Bramford to Twinstead Reinforcement

Document 6.6: Scoping Opinion

Proposed Bramford to Twinstead Overhead Line Project

Case Reference: EN020002

**FIGURE 4.1**

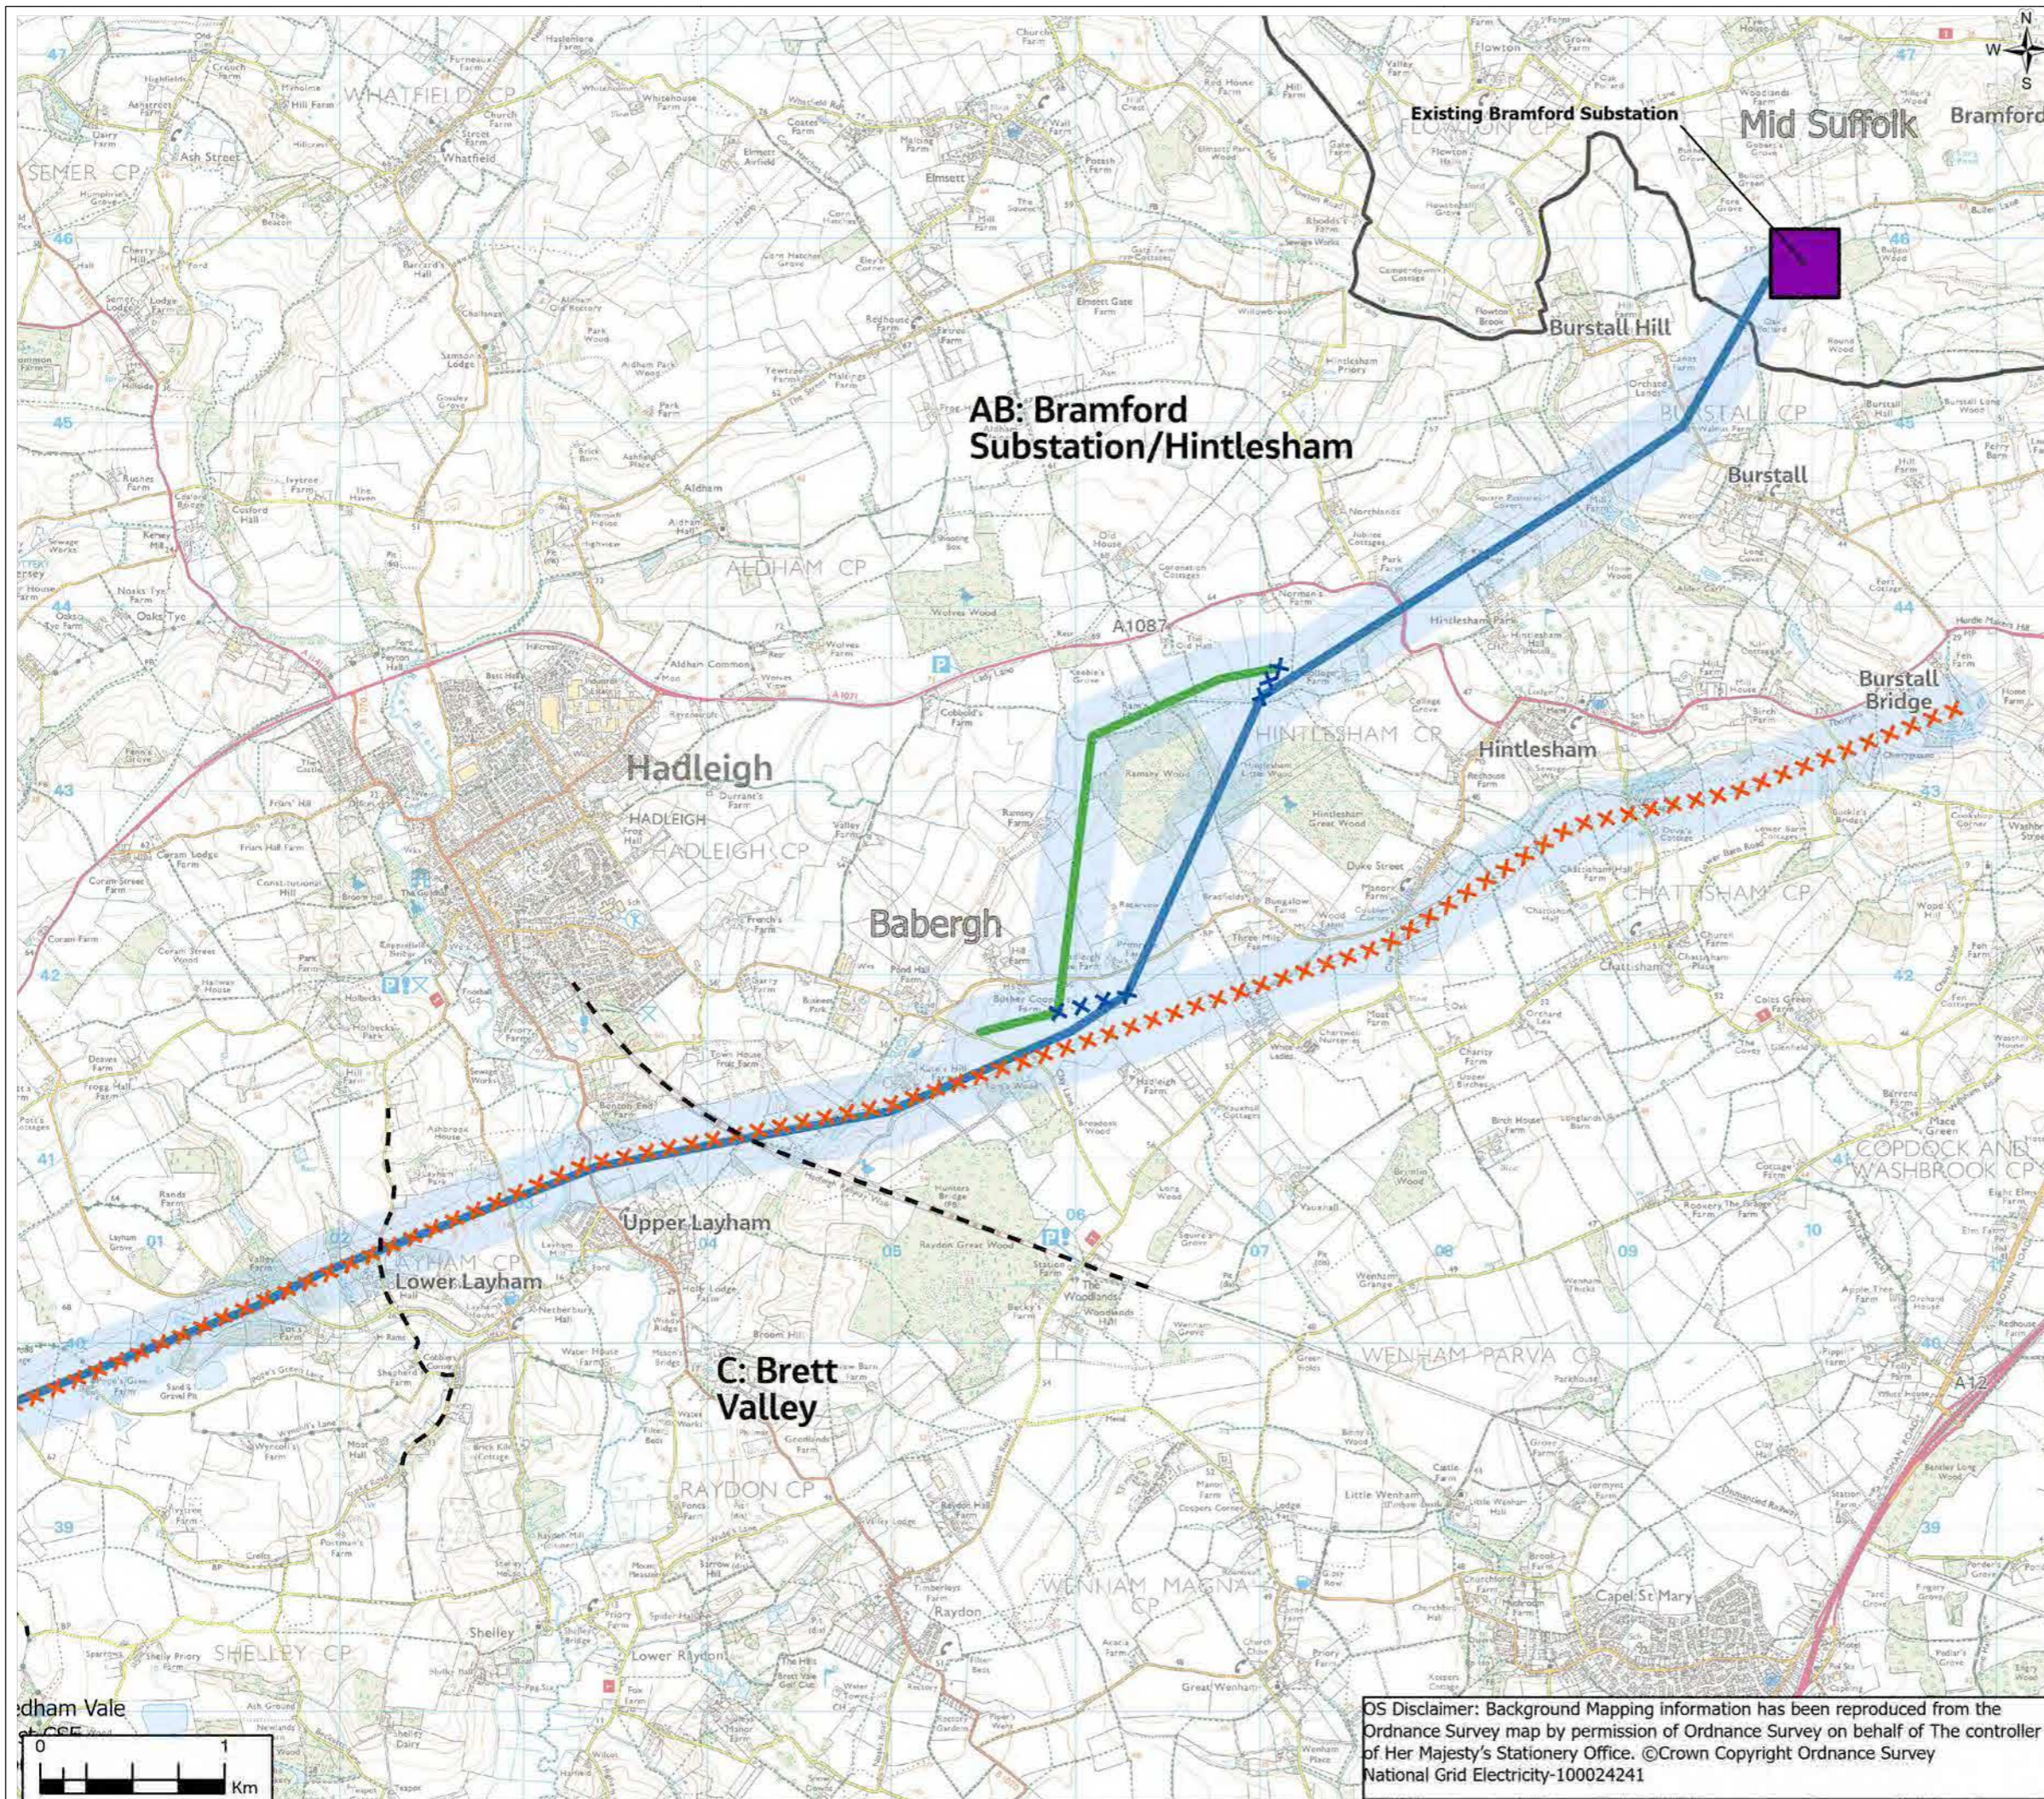
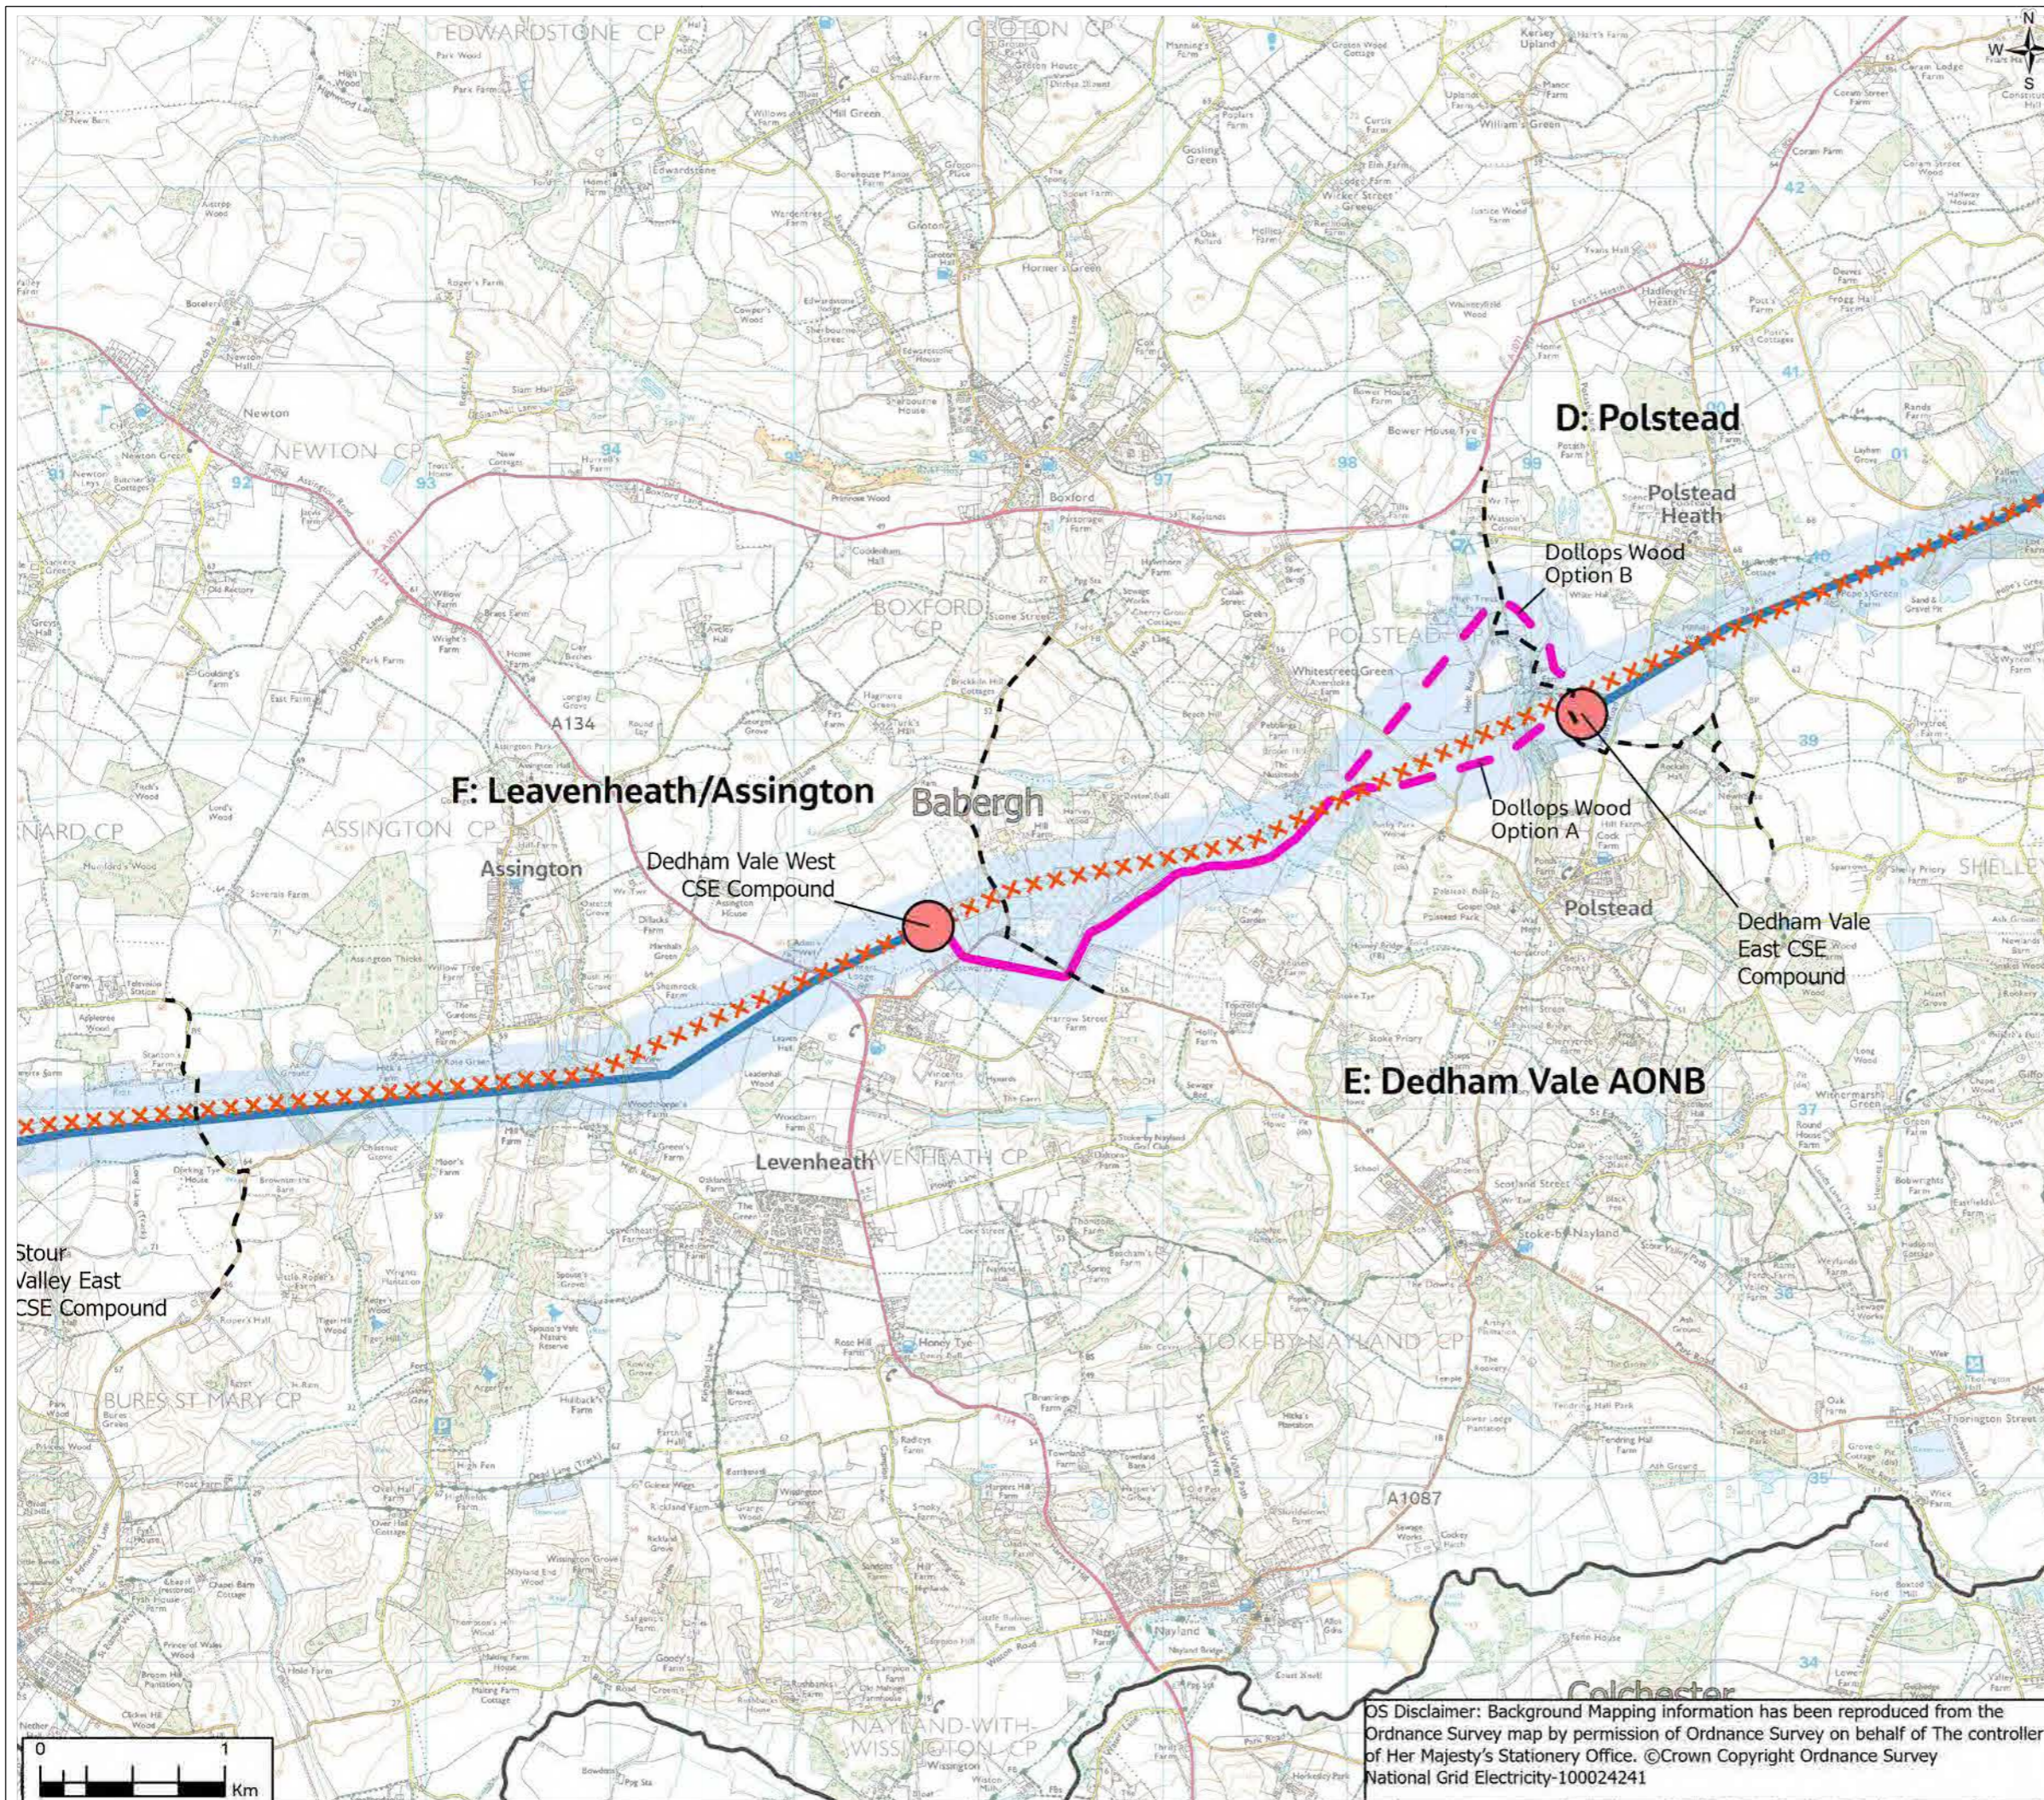
2.2.2 The Proposed Development involves construction and operation of a 400 kilovolt (kV) electricity transmission reinforcement between Bramford substation in Suffolk and Twinstead Tee in Essex following removal of existing 400kV and 132kV infrastructure, as illustrated on a series of plans presented at Figure 4.1 (Volume 3) (AAA_B2B_04_Proposed Development).

- 2.3.4 The Inspectorate notes that the final alignment of the proposed OHL is still to be confirmed and that there are options under consideration for routeing of the proposed underground cable at Dollops Wood and the siting of the CSEC at Dedham Vale East. The Applicant should make effort to fix the siting of each component and reduce uncertainty; where this is not possible, the Applicant

should ensure that the ES assesses a worst-case scenario adopting a parameters based approach.
